**RESPONSE TO SUBMISSIONS  
FOR CEMENT AND SLAG  
RECEIVAL AND DISPATCH  
TERMINAL, MAYFIELD NORTH**

Prepared by  
Umwelt (Australia) Pty Limited  
on behalf of  
Independent Cement & Lime Pty Ltd

Project Director: **Peter Jamieson**  
Project Manager: **Rod Williams**  
Report No. **2520/R09/Final**  
Date: **April 2013**

Figure 6: Project Layout

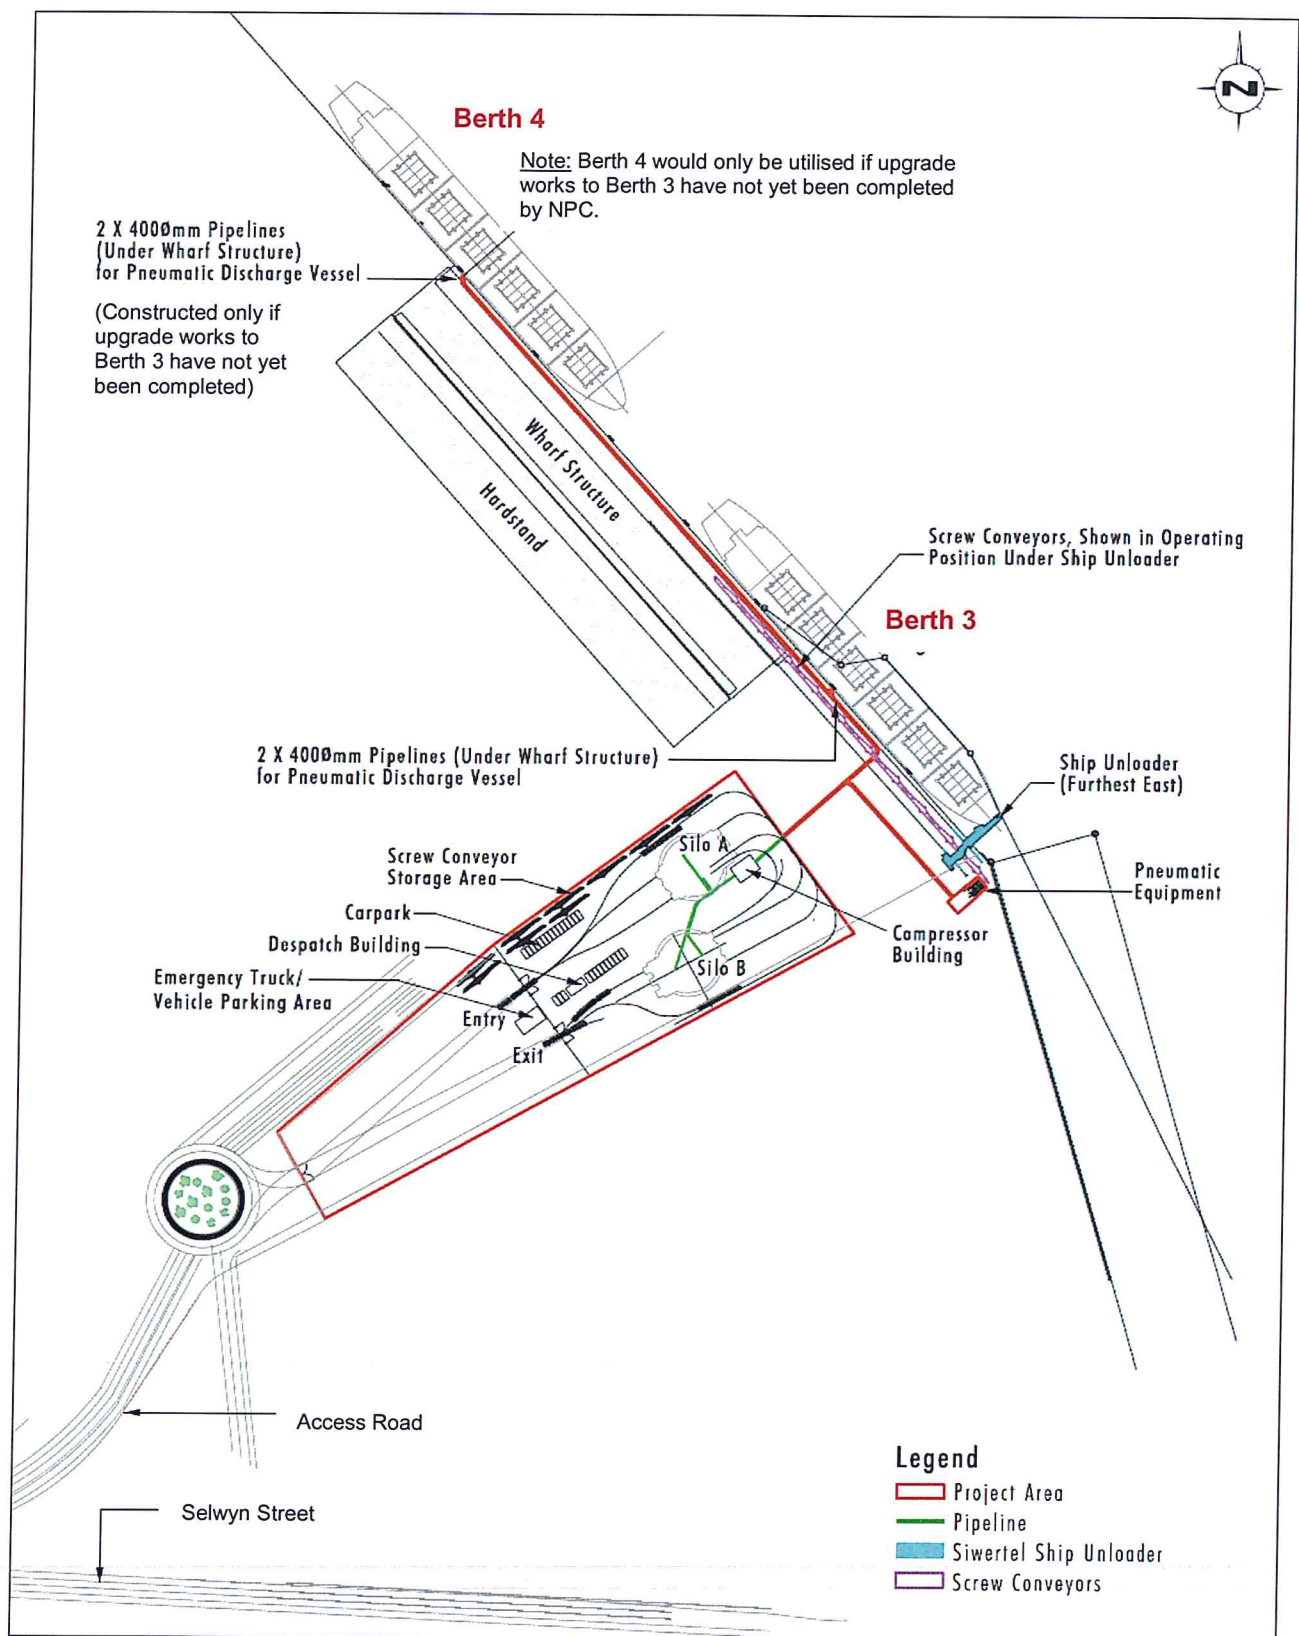
### **Construction of a dedicated emergency truck parking area within the site.**

**In Figure 2.1 of the EA there is a section of piping that is shown as above the wharf (Mayfield Wharf Silo South-East View). NPC require all links to the boundary of its leased area to be underground (excluding the mobile conveyors/augers).**

##### How will vehicles access the site in the long term.

**The EA indicates that the truck route will be via Selwyn St until such time the NPC has developed the Mayfield Concept Plan access roadway and from that time the new road will be used. Advice from the NPC is that the new roadway is under construction and should be available for use by the third quarter 2013. The NPC current thoughts on roadway use do not seem to be consistent with the initial roadway proposal for the concept plan.**

The Project includes a dedicated emergency truck parking area within the site (refer to **Figure 2.1** of the EA attached).

The establishment of the permanent access points and internal road network within the closure area is the responsibility of NPC. The permanent vehicle access point to the site will be via Selwyn Street. The internal access road arrangement it its connection with Selwyn Street is shown on **Figure 2.1** of the EA (attached).

The permanent internal access road arrangement and its connection with Selwyn Street has been provided to ICL by NPC and is shown on Figure 2.1 of the EA (attached). The issue of the internal roadways being inconsistent with the Concept Plan is a matter that NPC needs to consider and address, as it is outside the scope of this Project. The internal road network was approved as part of NPC's Mayfield Concept Plan Approval and is therefore the subject of a separate approval.
